Harnett County Government Complex
307 Cornelius Harnett Boulevard
Lillington, NC 27546

April 11, 2008

**Re: Status of Improvement Permit Application #08-5-19823
Persimmon Hill Lt 23**

P&S Home Builders, LLC  
Lot #23 Persimmon Hill  
310 Old Field Loop

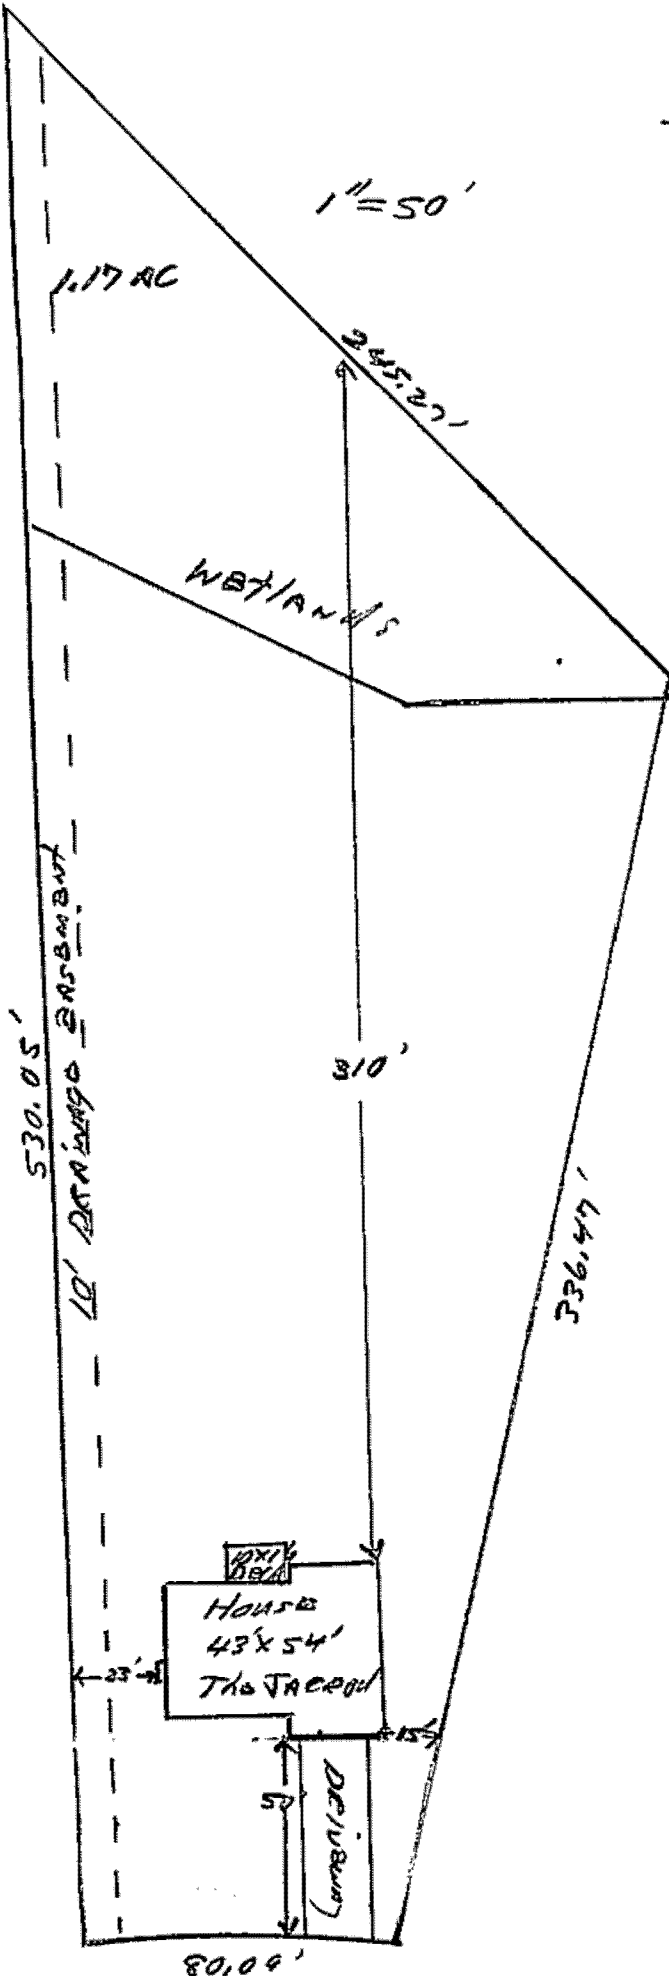
- 1. Property lines/corners not marked or labeled
- 2. House corners not marked or labeled
- 3. Directions not clear to property
- 4. Property needs brush or vegetation removed
- 5. Backhoe pits required
- 6. Other – Due to storm pond location, required setback of 50', and house size of 4 bedrooms, you will need to get your private soil consultant to provide septic system and repair layout.
